Your Ref: OWQC24418
Our Ref: EP/108/19/HH
Please ask for:
Mr Z Denton

26th September 2019

Two storey front, two storey side and two storey rear extension and additional parking bay to garage
Caprice 17 Tamarisk Way East Preston

Elevations
as Proposed

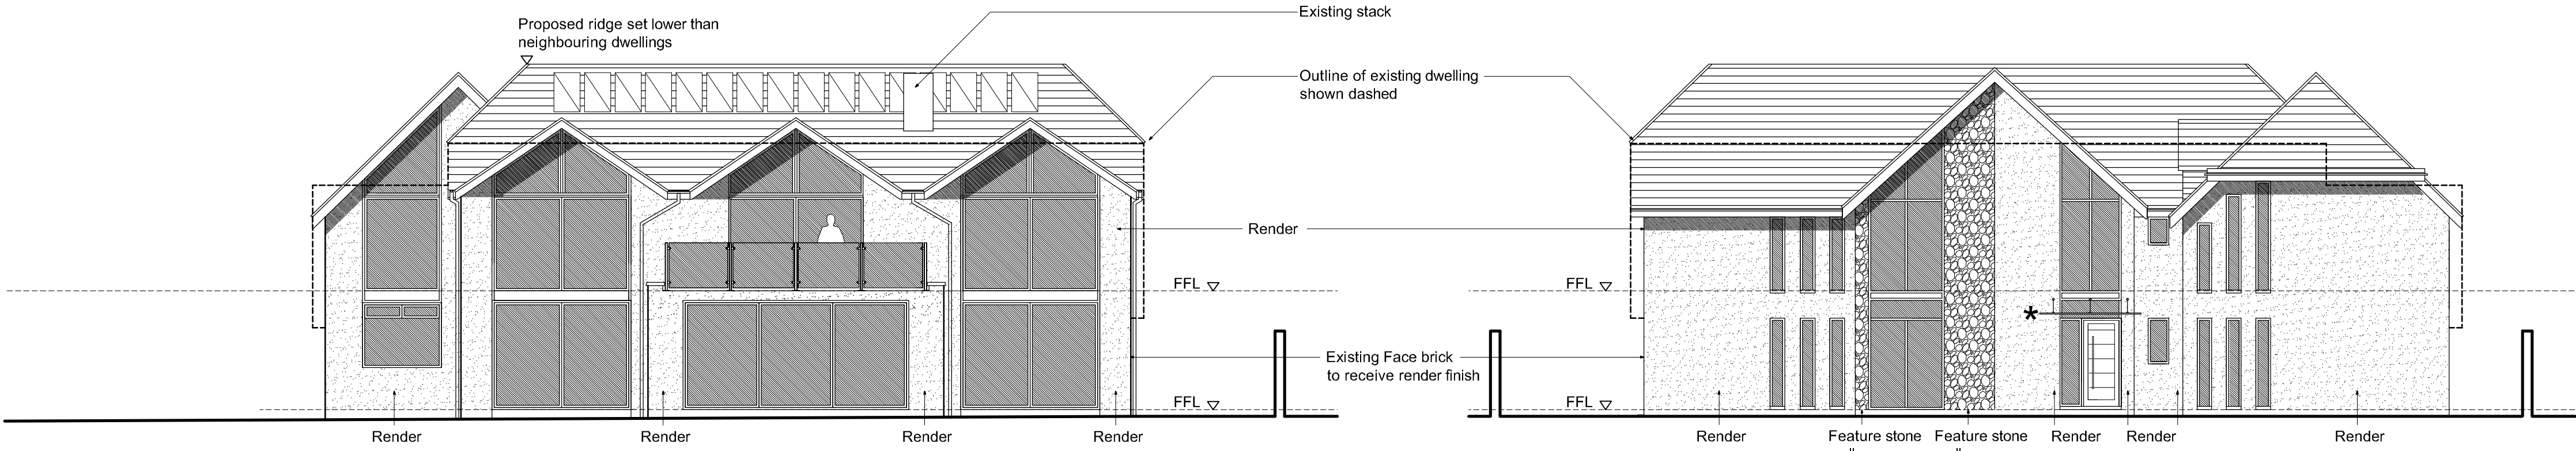
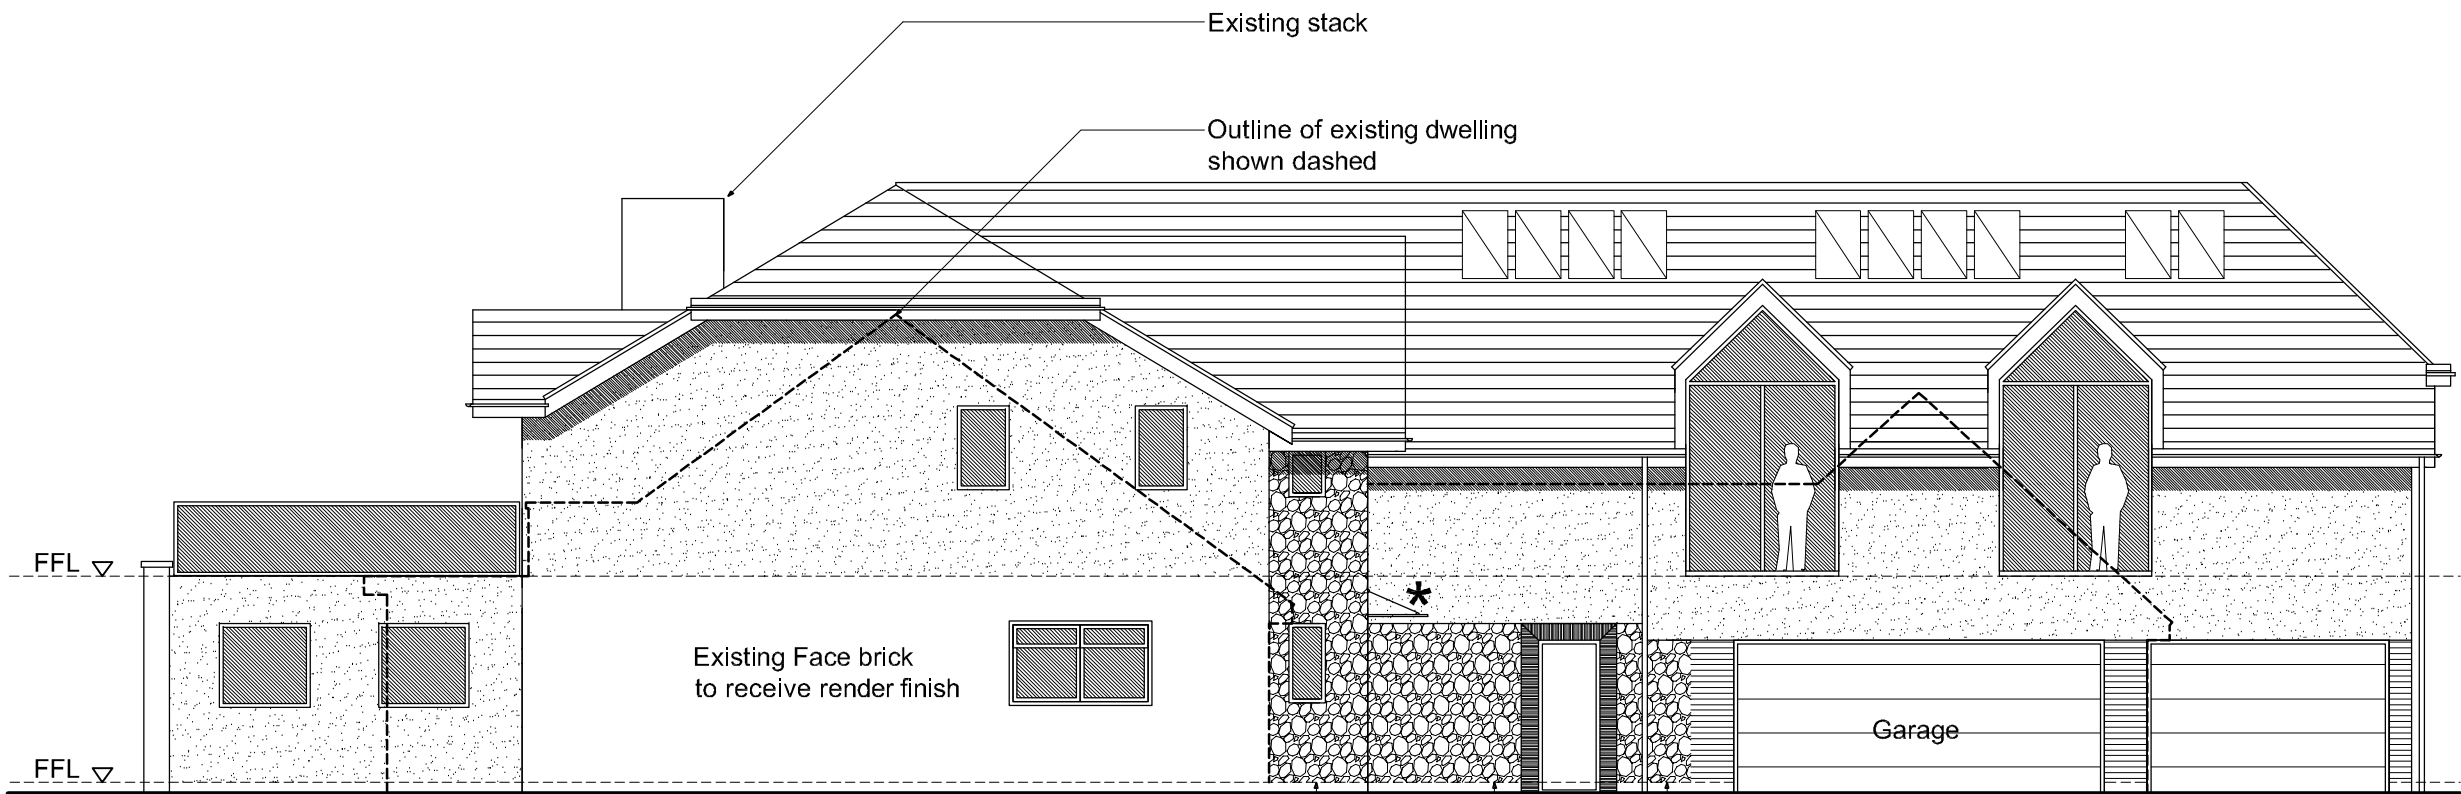
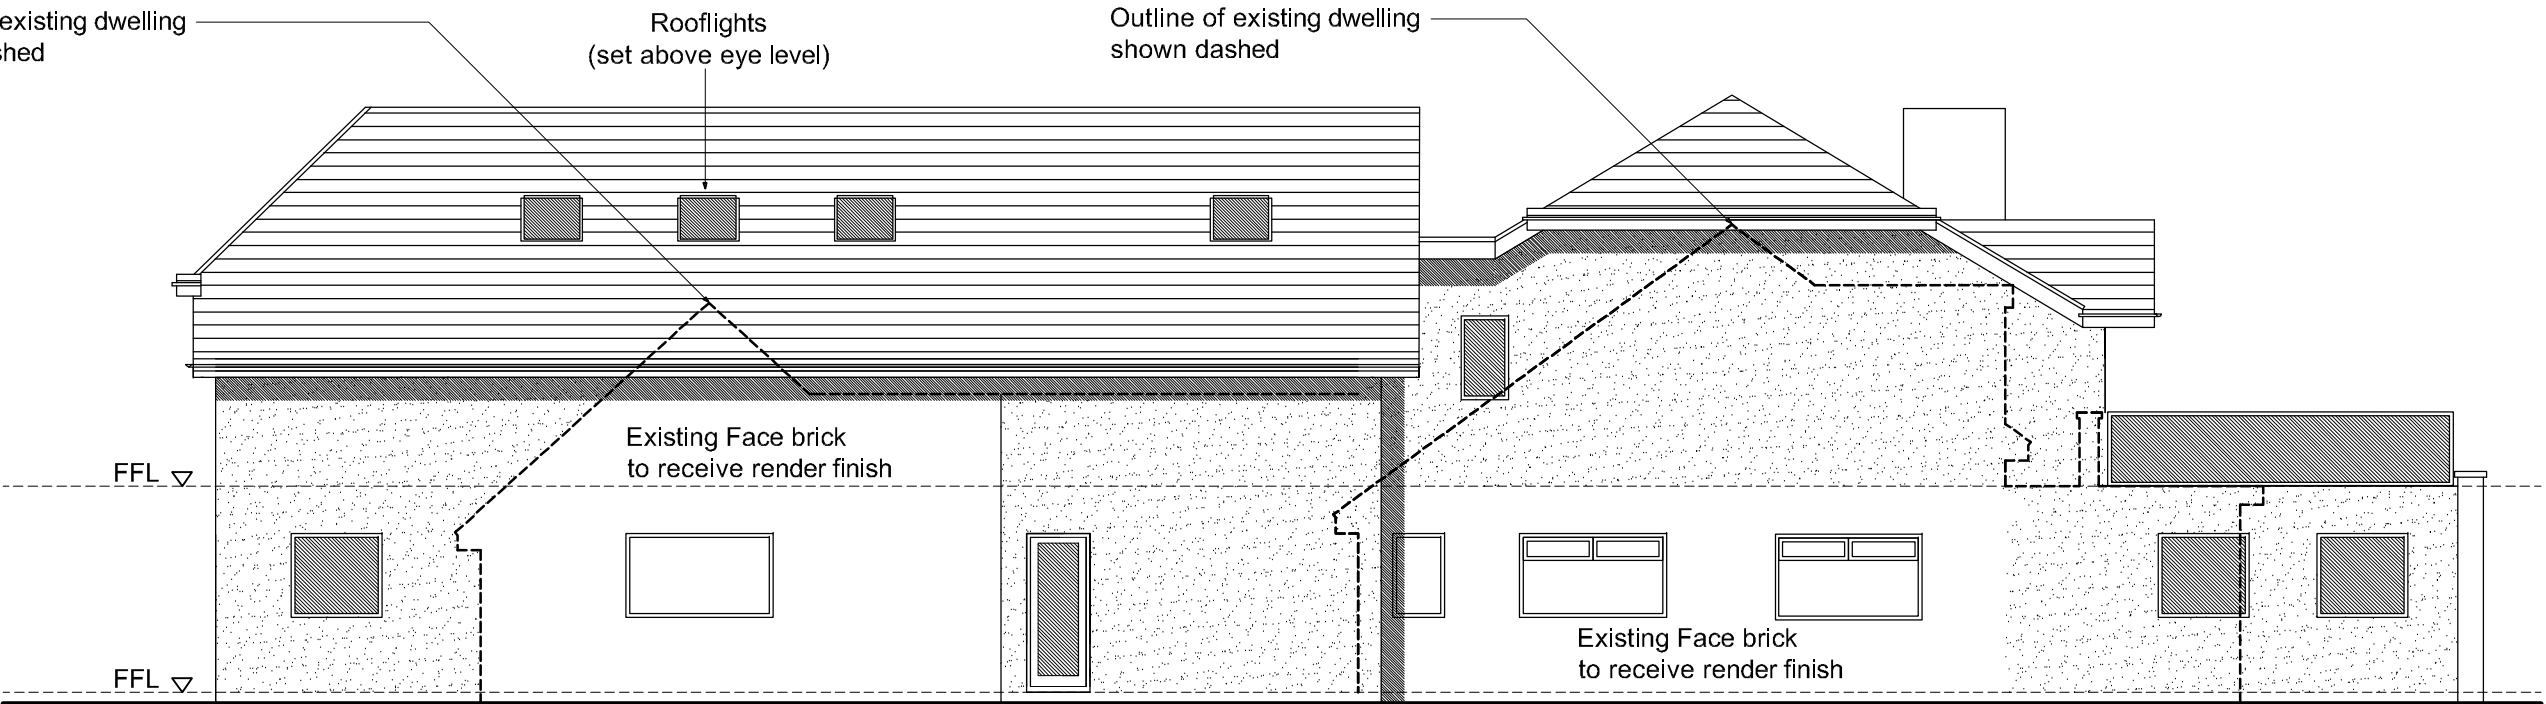
The committee agreed not to raise any objections to the proposed development but asked for it to be stressed the materials chosen should harmonise with the neighbouring properties, as per section 4.12 of the made East Preston Neighbourhood Plan.
